**From:** Robert Findlay  
**Sent:** 12 August 2008 12:24  
**To:** Planning.Responses  
**Subject:** FW: Planning Consultation on: BR/238/08/

**APPLICATION NO:** BR/238/08/

**Registered:** 06-AUG-08  
**Site Address:** 7 Annandale Avenue Bognor Regis

**Description of Works:** Erection of first floor rear extension and conversion of rear projection to 1 x 2 bed flat

GROUND FLOOR PLAN
PROPOSED

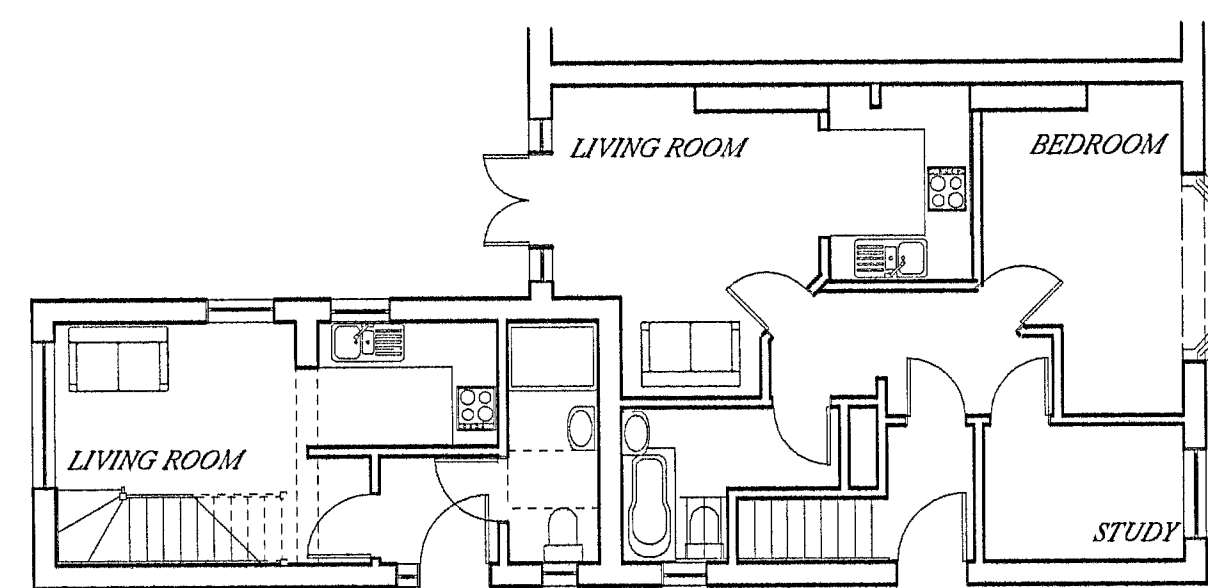
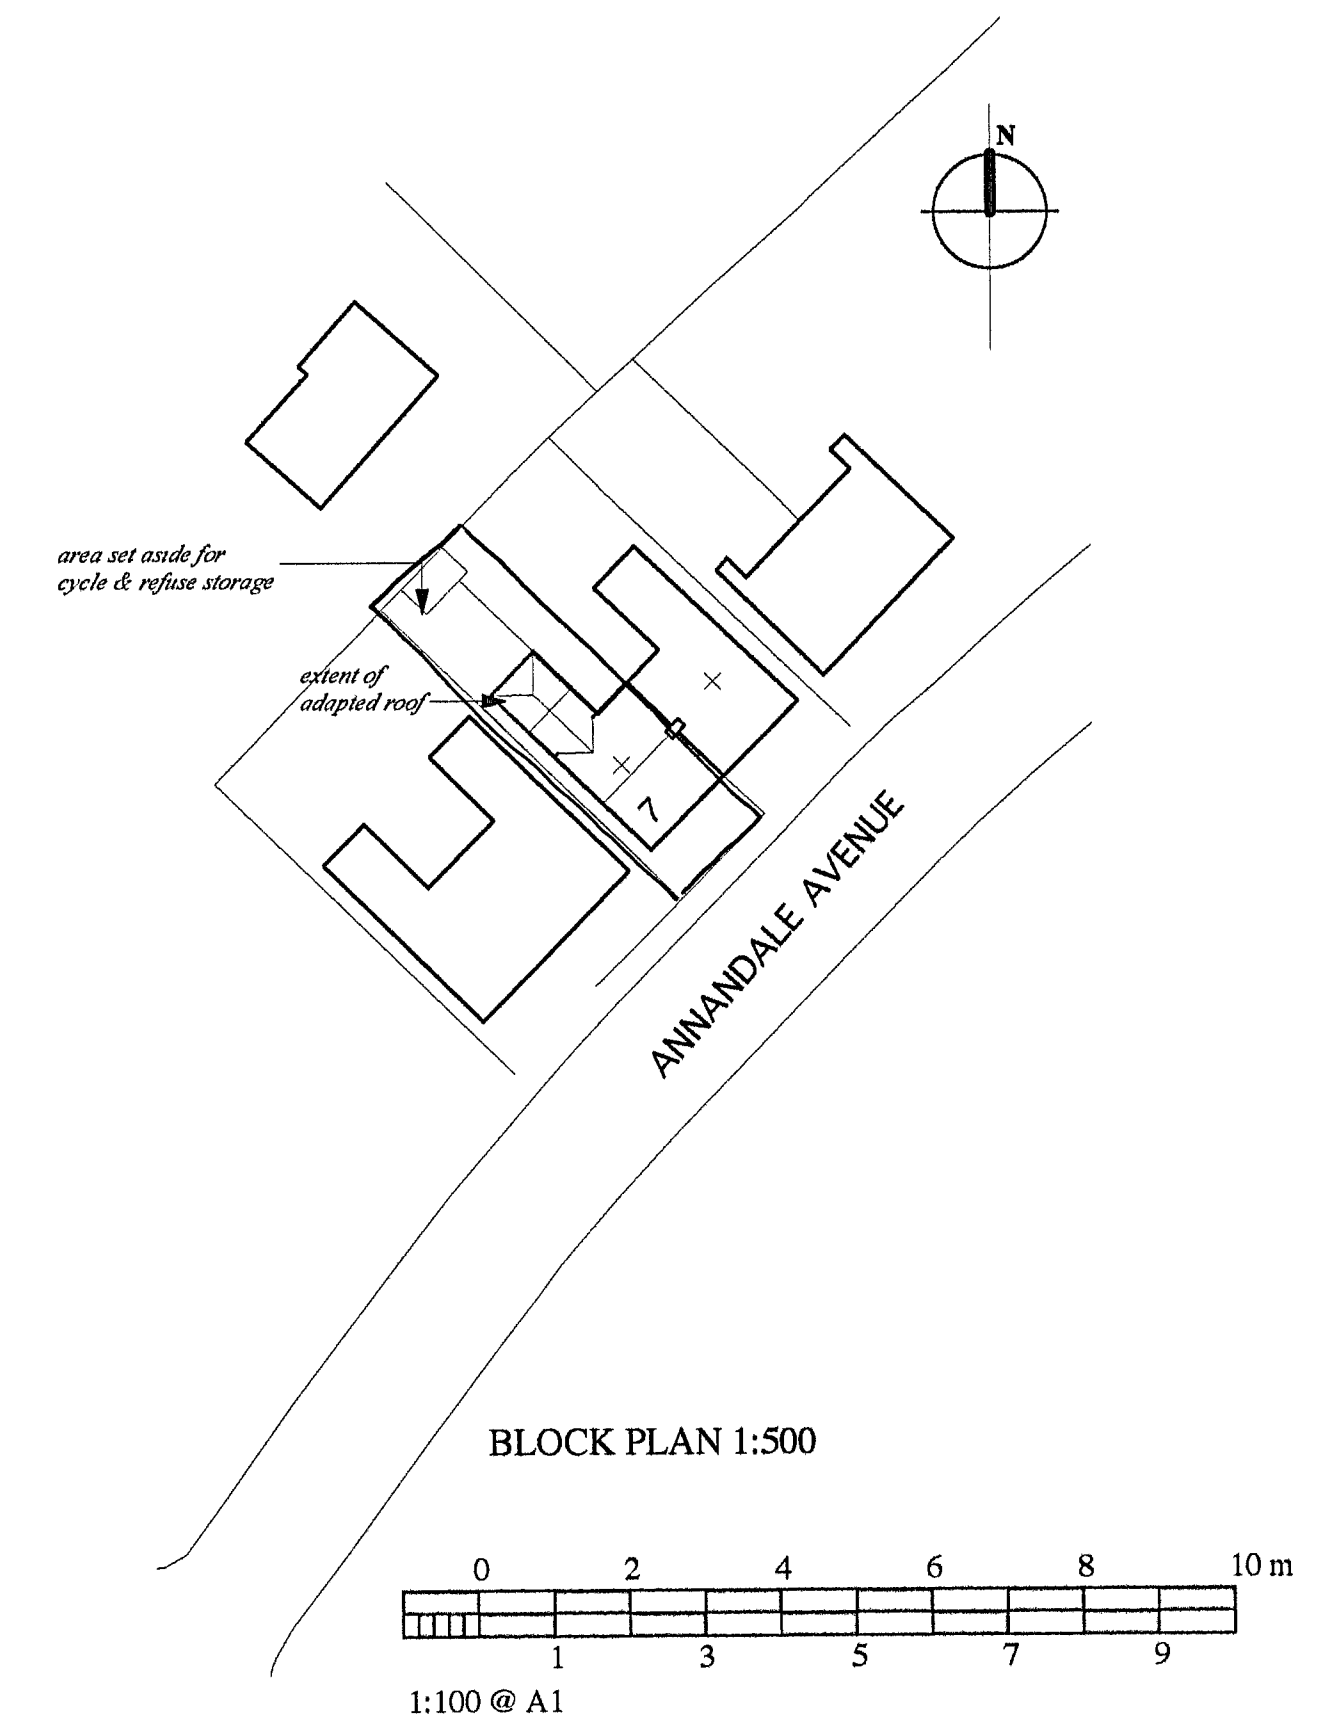
No adverse comments other than there appears to be no provision for refuse storage.
